TAMLIN ROAD STORAGE

EL PASO COUNTY, COLORADO

ZONE CHANGE EXHIBIT

Markup Summary

ZONE CHANGE EXHIBIT

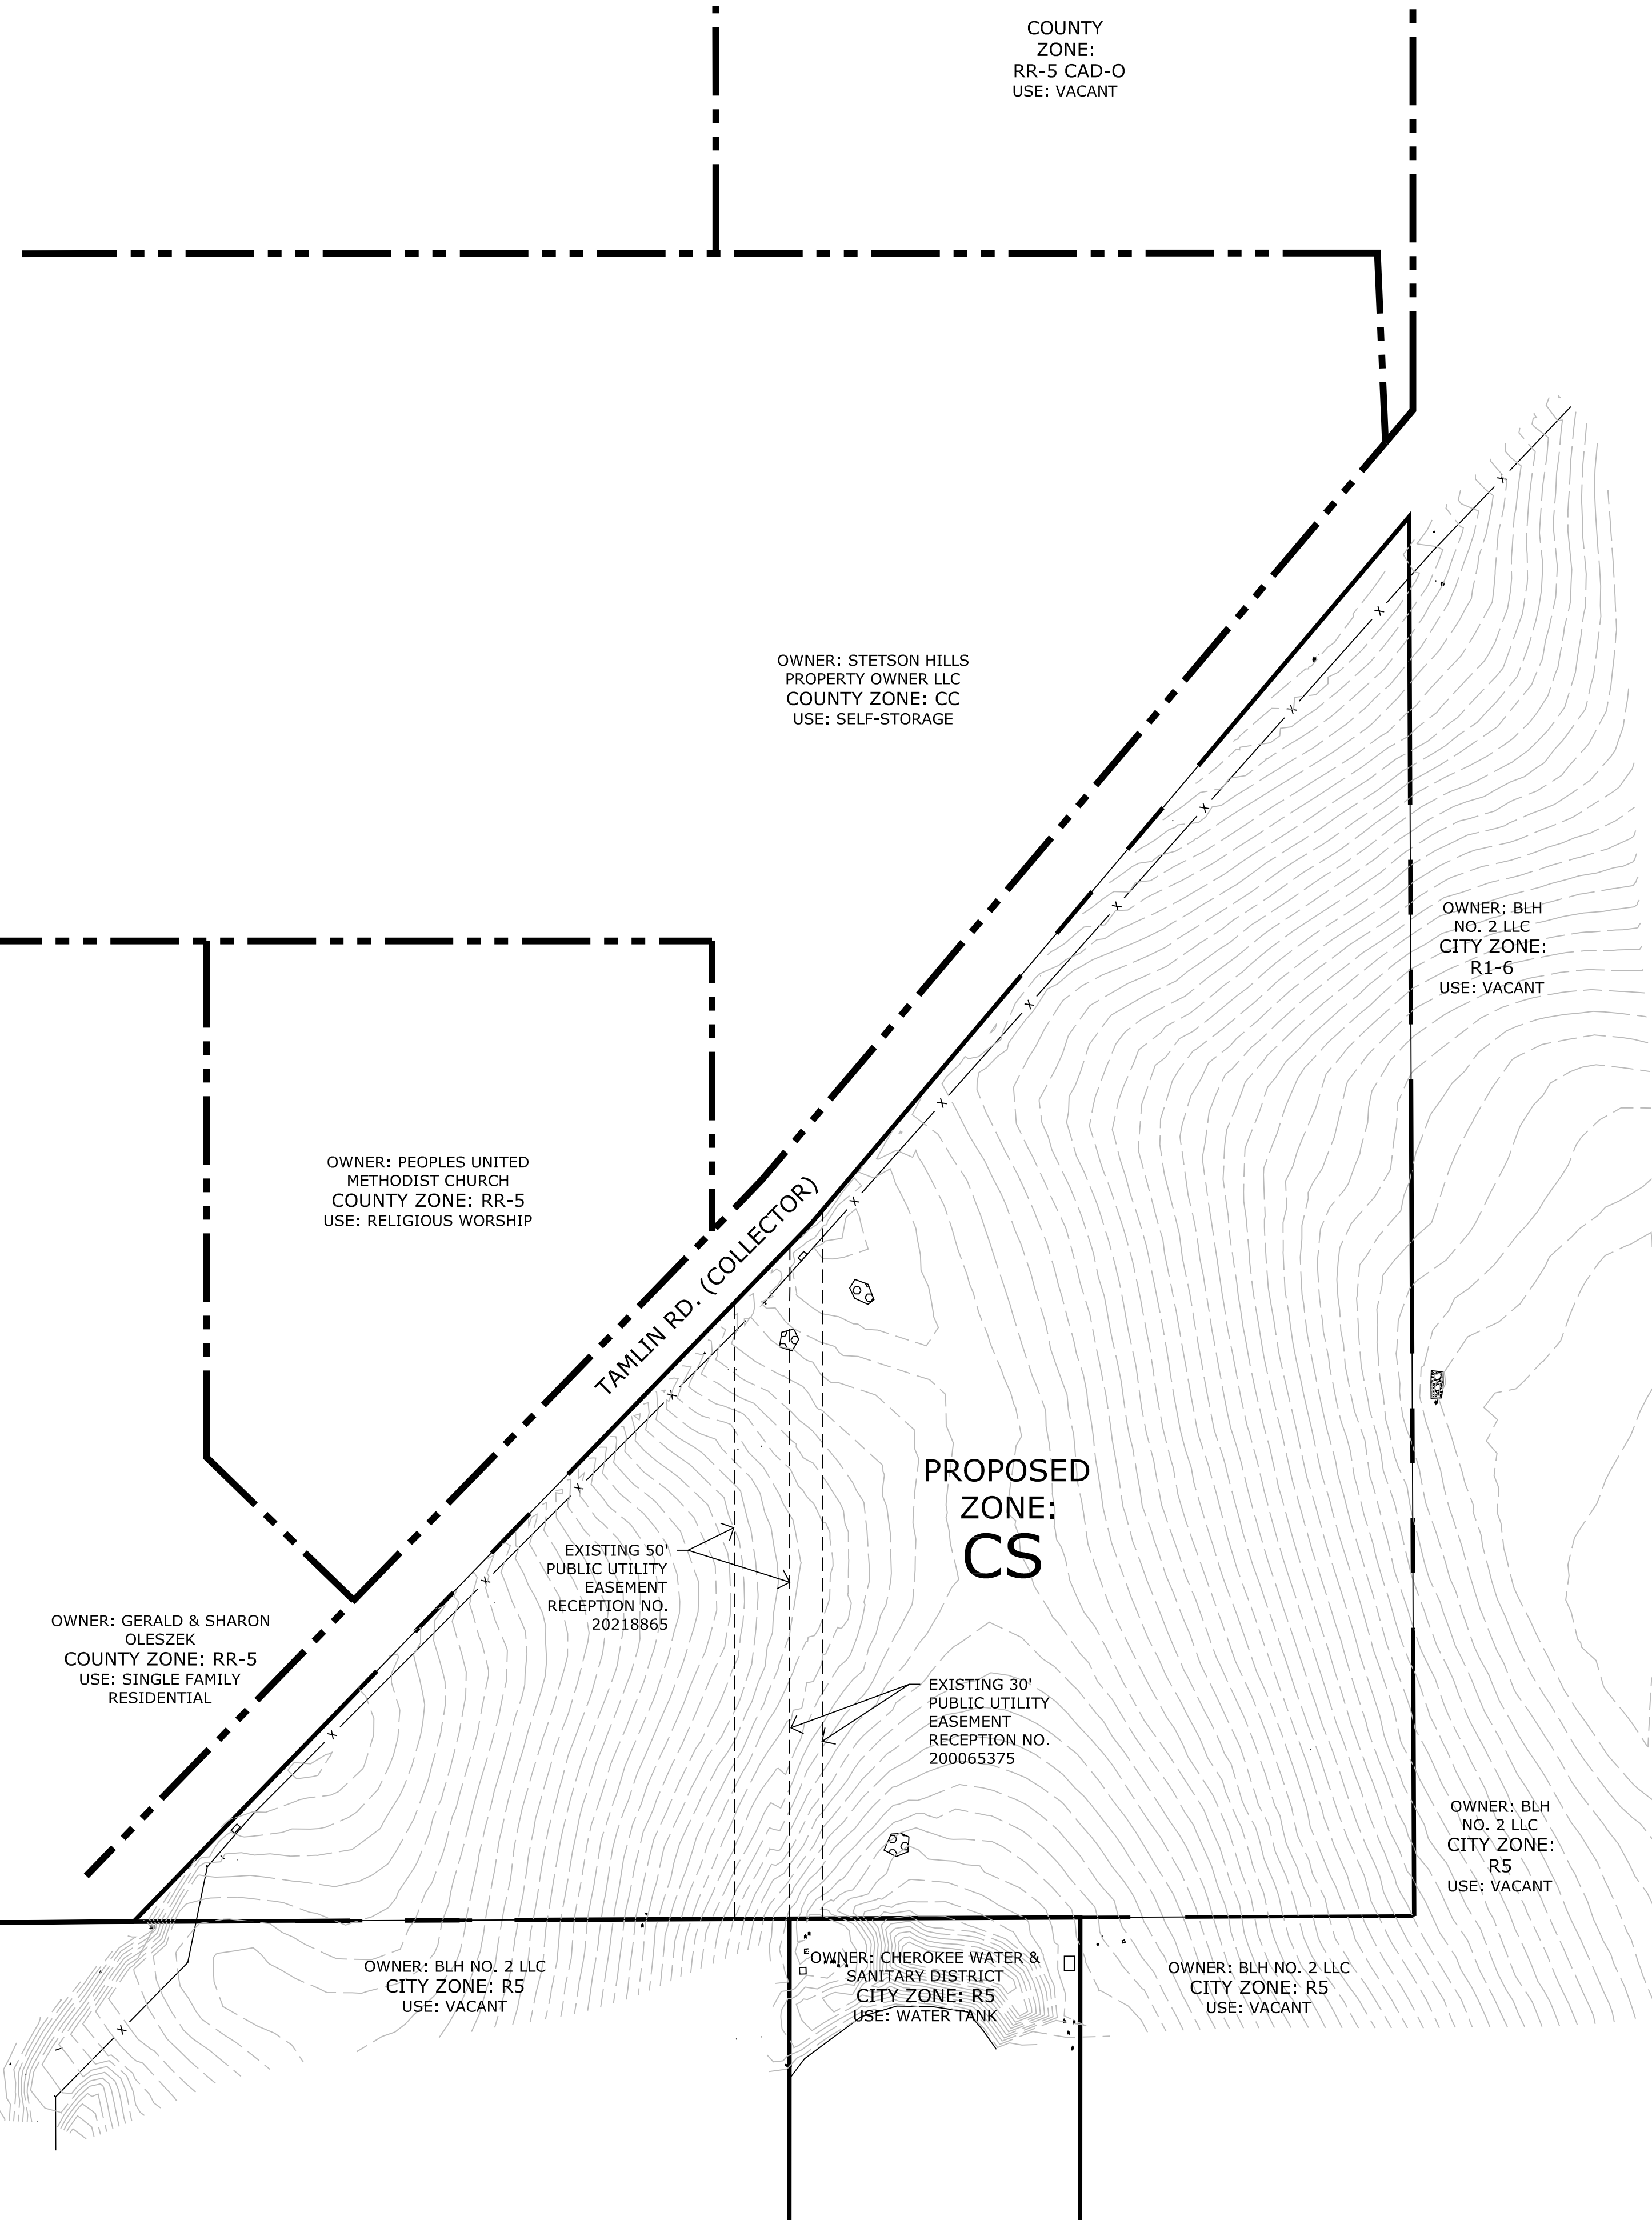
Show and label all easements as shown in the title commitment.

Show all land uses within 500 feet of the property, include the residential land use up to 500 feet away from the property.
